DRB CASE NO/PROJECT NO: 1002347

DEVELOPMENT REVIEW BOARD--SPEED MEMO

CITY OF ALBUQUERQUE PLANNING DEPARTMENT Development Review Board Comments

Subject: Monkbridge Addition

PLAT OF
 OF
 LOT 36-A, BLOCK B,
MONKBRIDGE ADDITION
 WITHIN
 SECTION 5, TOWNSHIP 10 NORTH, RANGE 3 EAST,
 NEW MEXICO PRINCIPAL MERIDIAN
 CITY OF ALBUQUERQUE
 BERNALILLO COUNTY, NEW MEXICO
 DECEMBER 2002

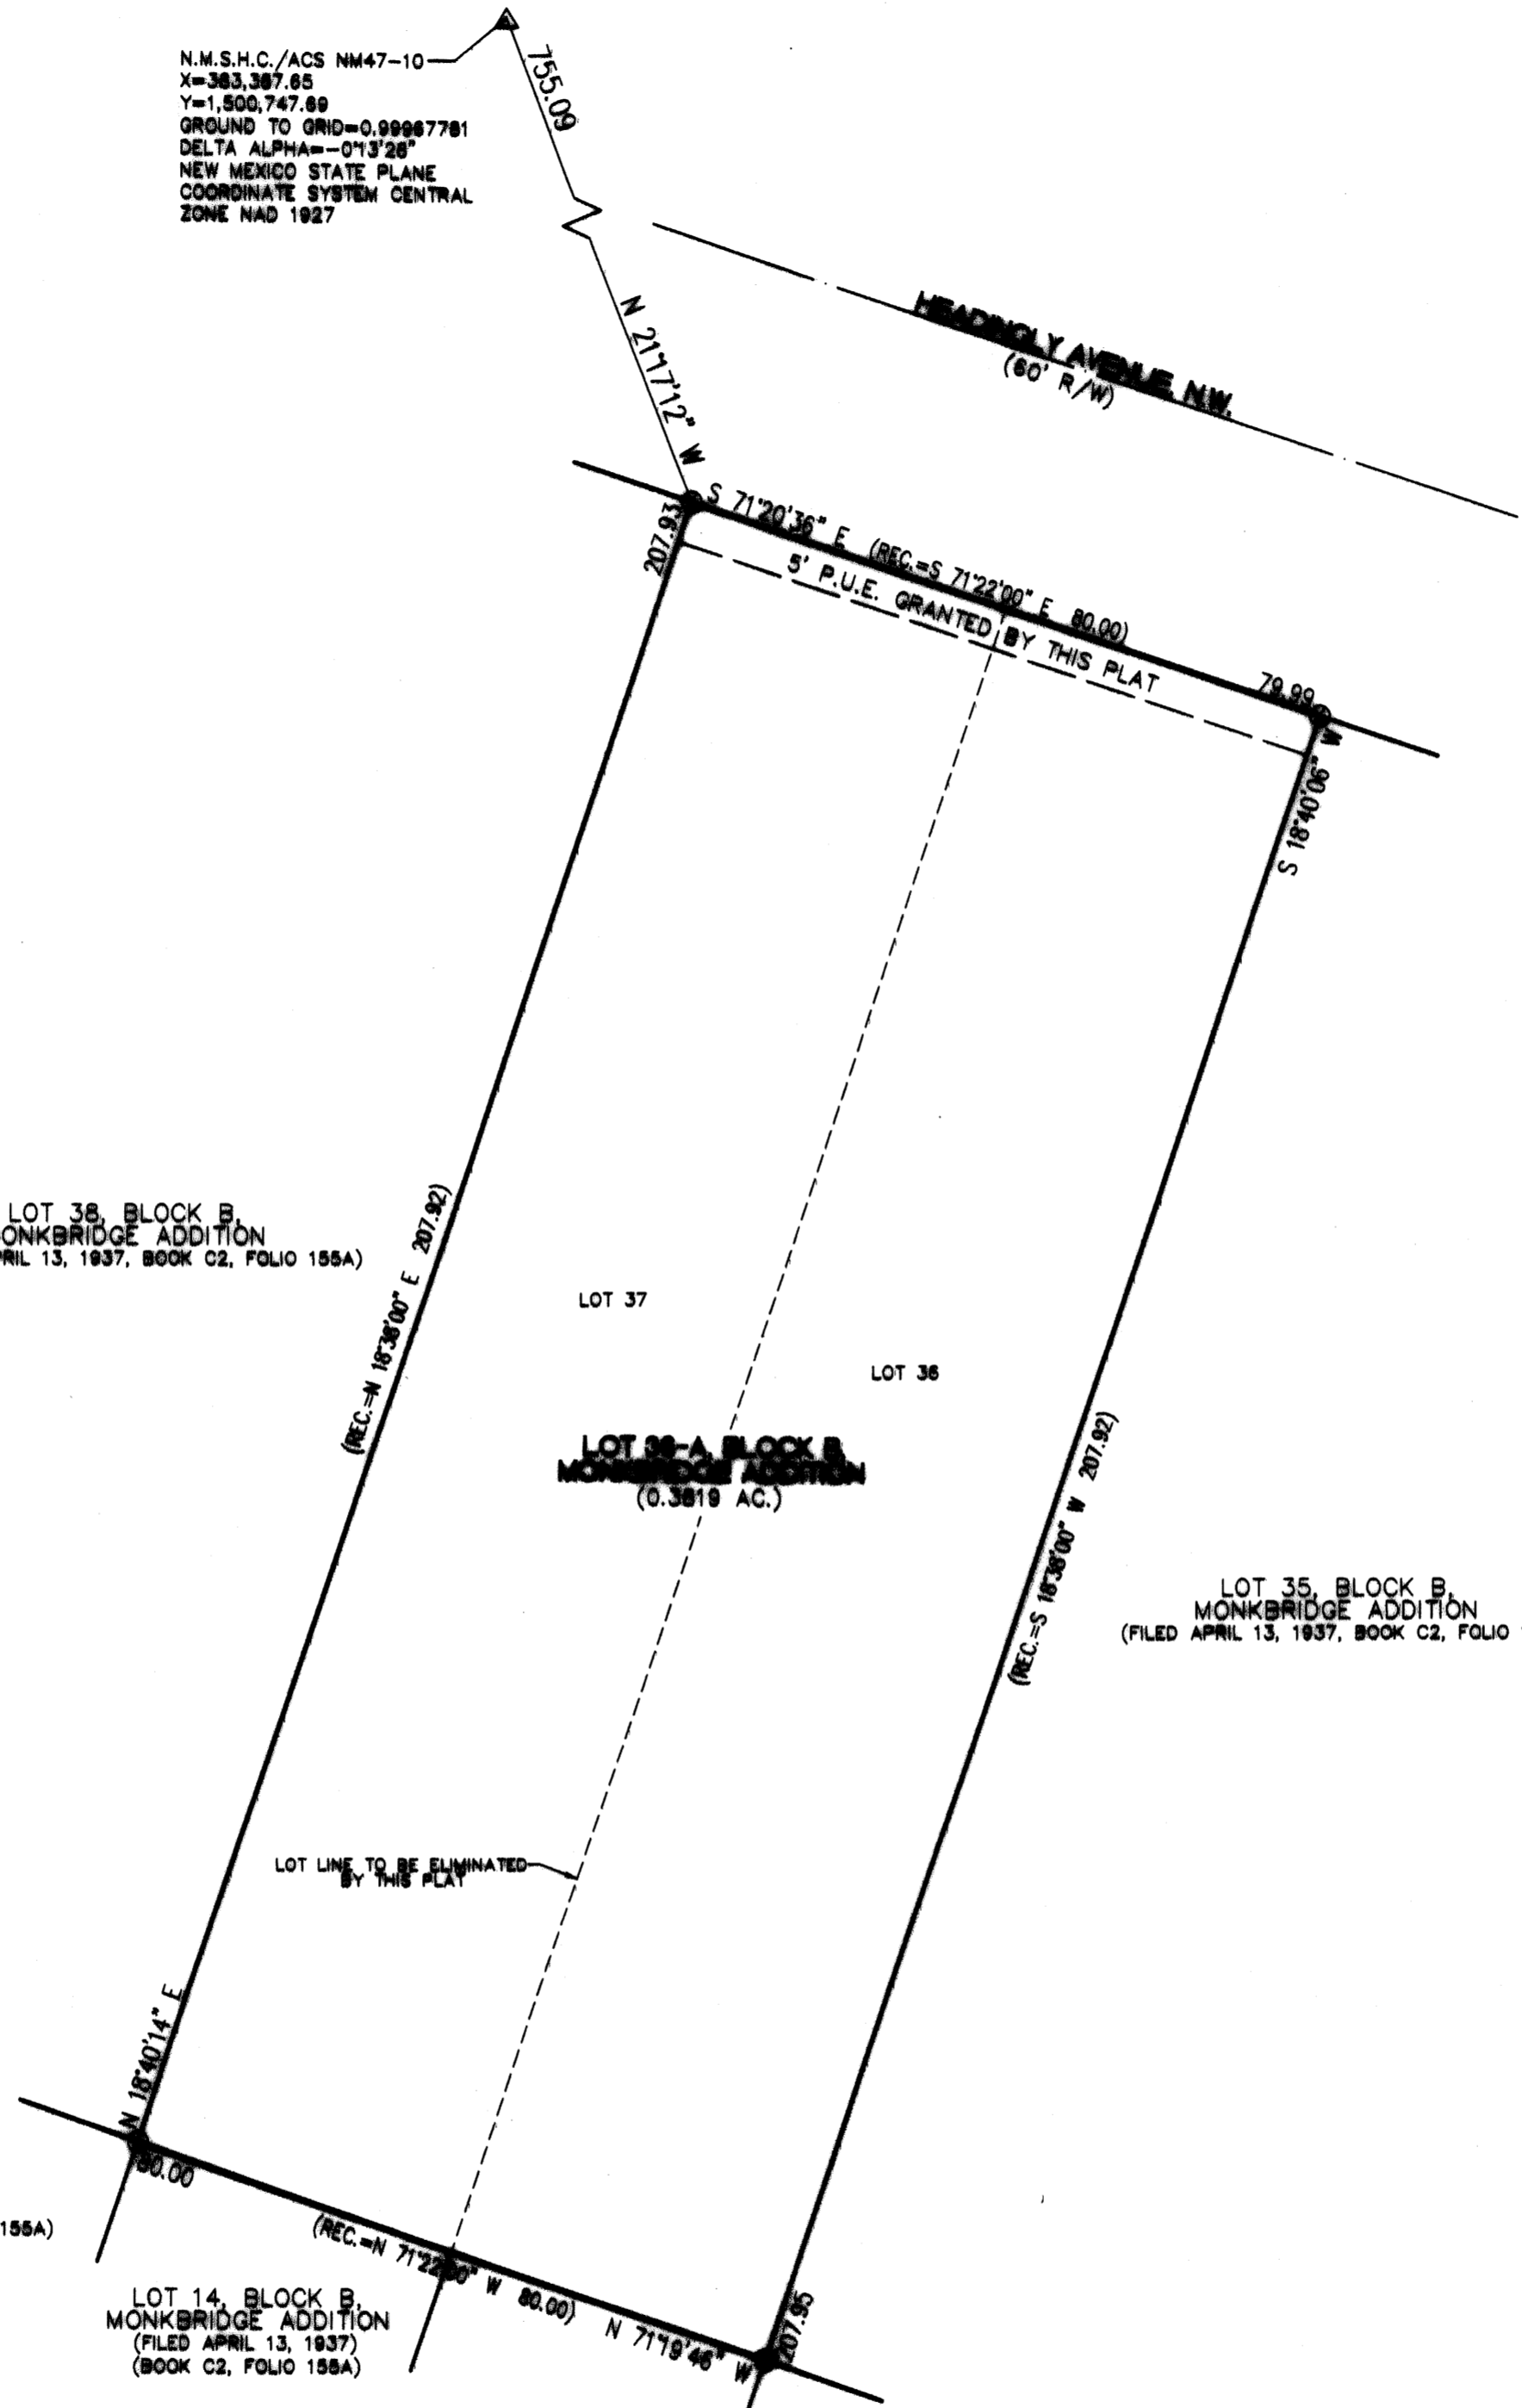
The key for the numbers shown on the submittal marked "site plan" would be helpful. For example, is #13 a structure? If so a 5' setback is required for M1 zoned property per the City Zoning Code.

The relationship between the existing lot lines and the proposed is not clear.

The plat itself should state the Purpose of Plat.
